Application No: EP/58/21/HH
Site Address: Mistibeech 15 Tamarisk Way East Preston BN16 2TF
Description of works: Erection of part single, part two storey rear extension with roof terrace, garden outbuilding in rear and detached garage to front following the demolition of existing sun room and roof terraces

This council's Planning & Licensing Committee considered this Application at its meeting on Monday, 28th June.

This drawing is the property of Inspired Design Studio Limited and must not be copied, reproduced or passed to a third party without their permission.

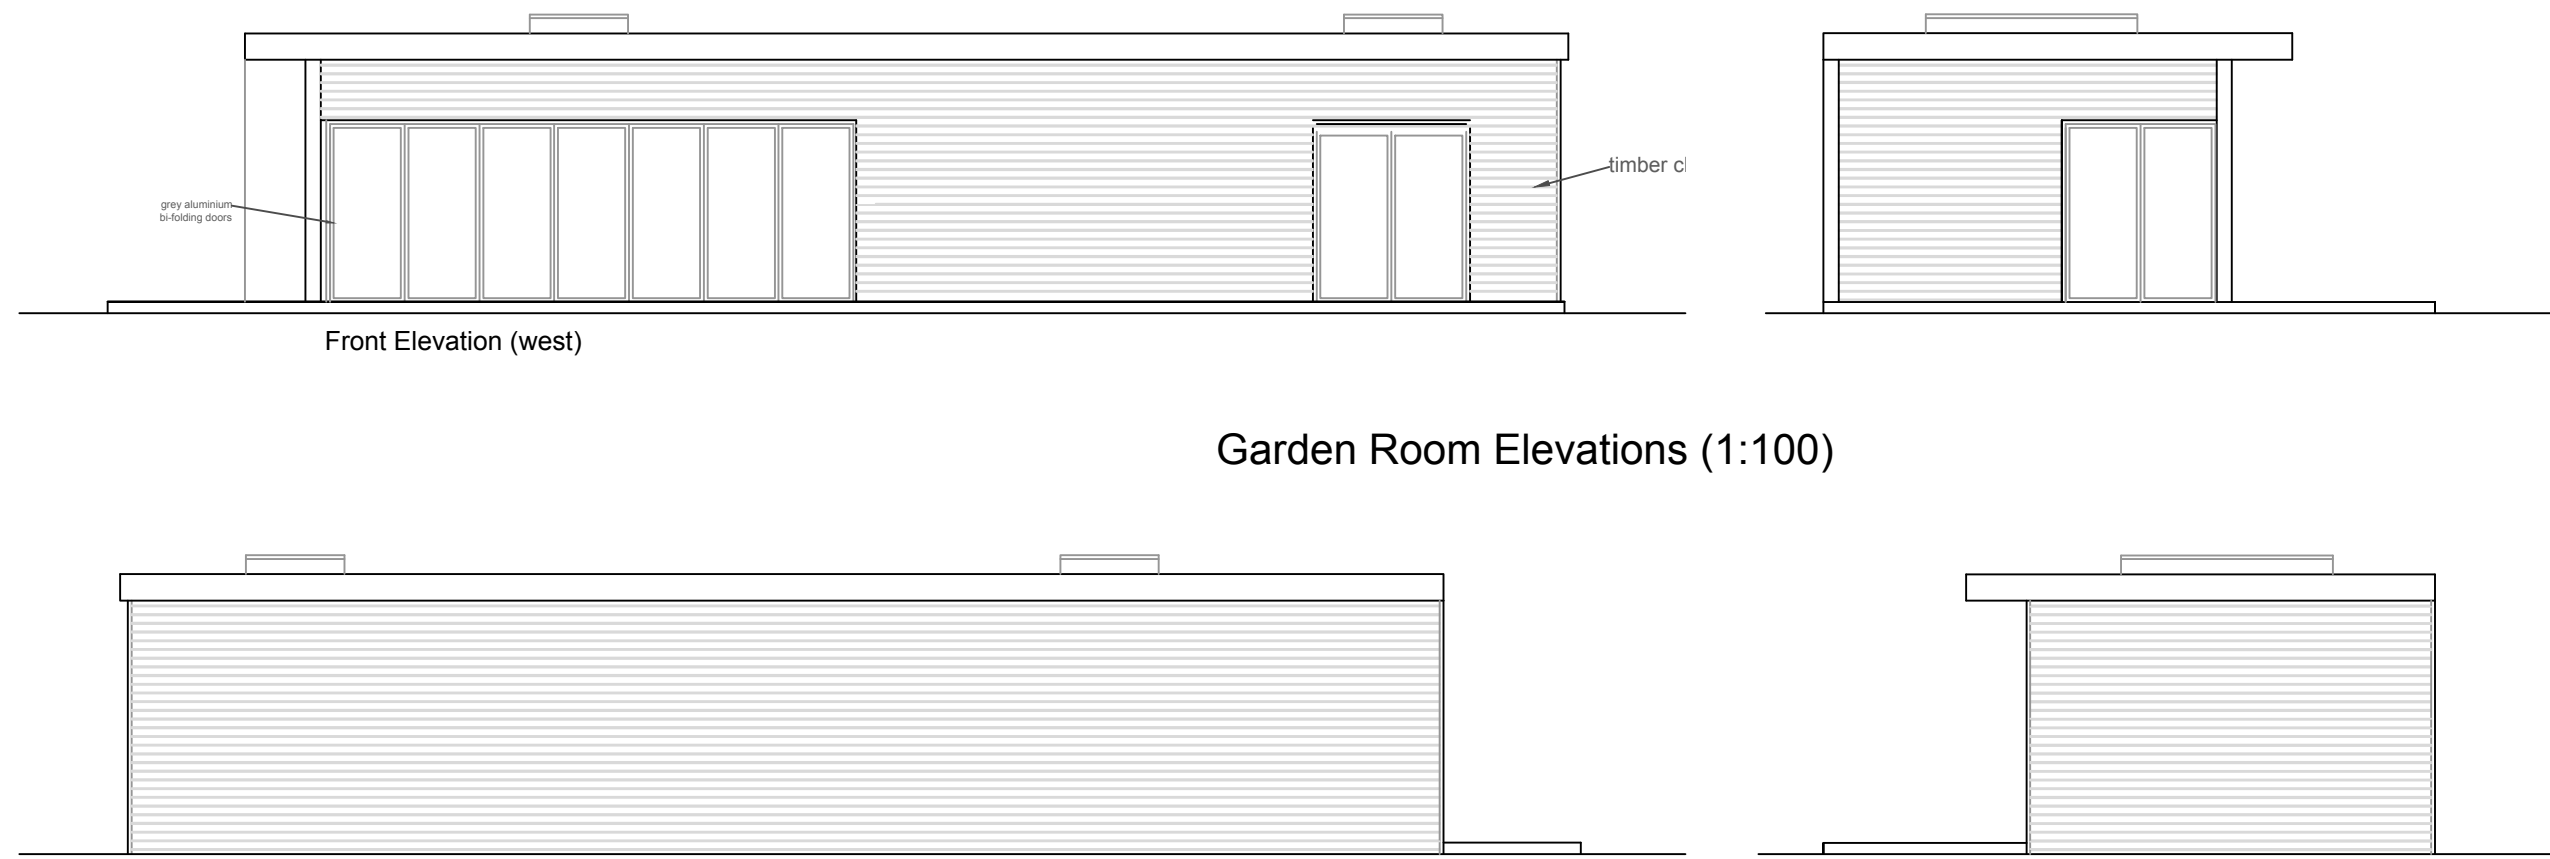
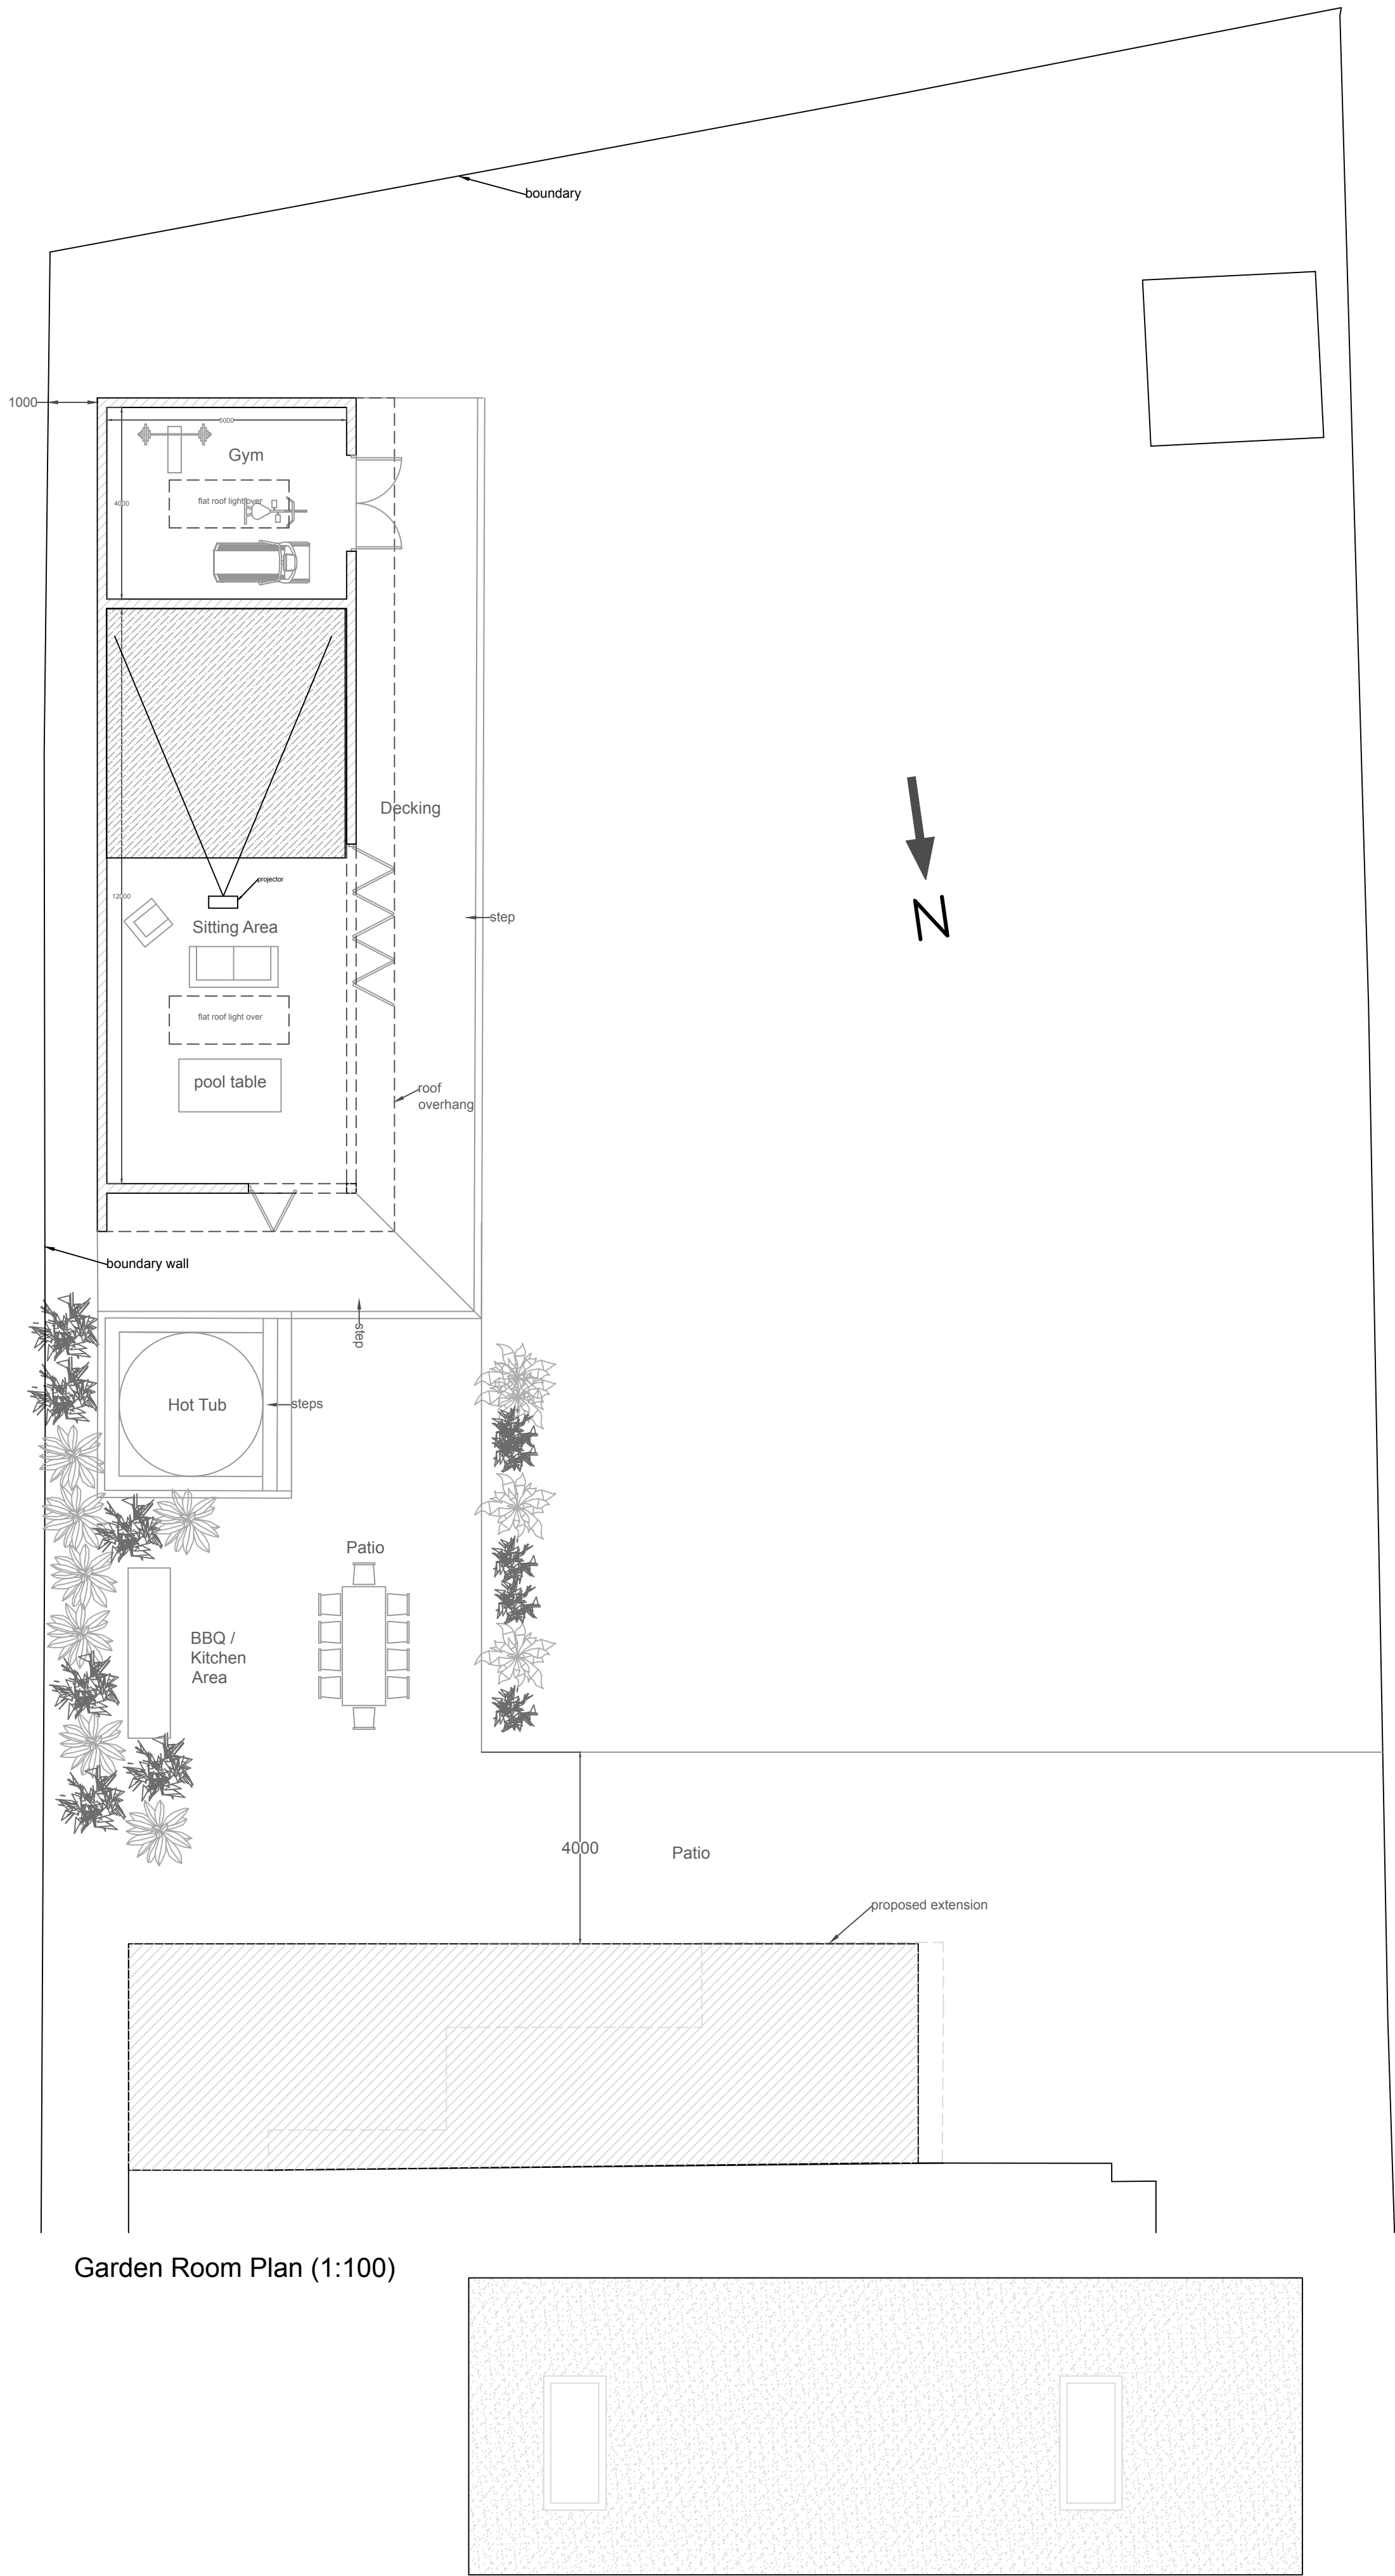
The proposed garage is set too far forward on the plot and would have an unacceptable impact upon the streetscene.

As no proposed North elevation has been provided, the committee has been unable to consider the impact the proposed garage will have upon the look of the building itself. However, the committee felt the proposed garage was likely too far from the existing building to integrate visually with it. We believe this to be in conflict with policies D DM1 and D DM4 of the Arun Local Plan and the East Preston Neighbourhood Plan.
